From: ENVU Biodiversity and Land Use
Sent: 24 September 2025 08:51
To: Planning ContactCentre
Subject: 2025/92461 at location adj, 26, East Street, Lindley, Huddersfield, HD3 3NE

4. Existing approved triple garage to be demolished for the new dwelling (methodist church in the background)

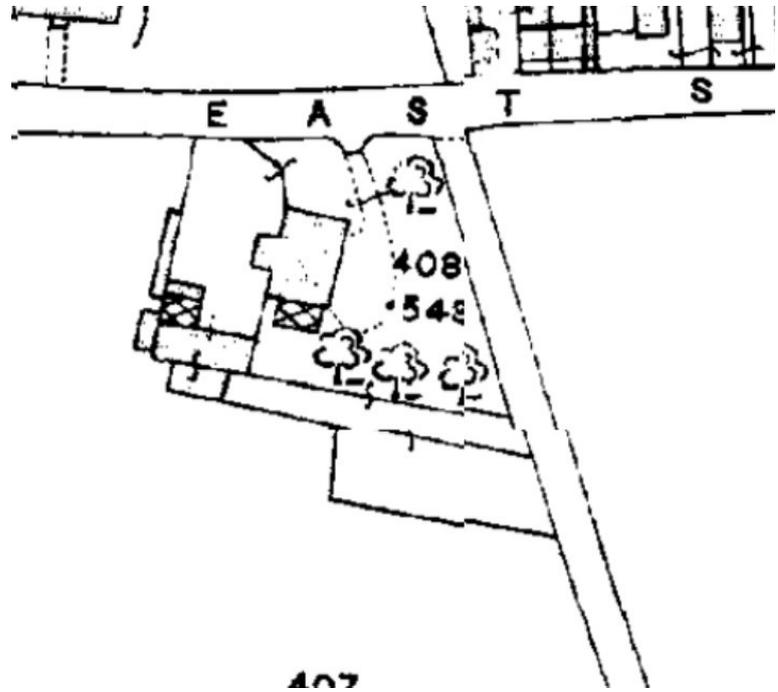
The building to be demolished appears to have features that would be suitable for roosting bats (e.g. loose / missing tiles) and nesting birds.

It is recommended that a Preliminary Bat Roost Assessment is conducted prior to determination.
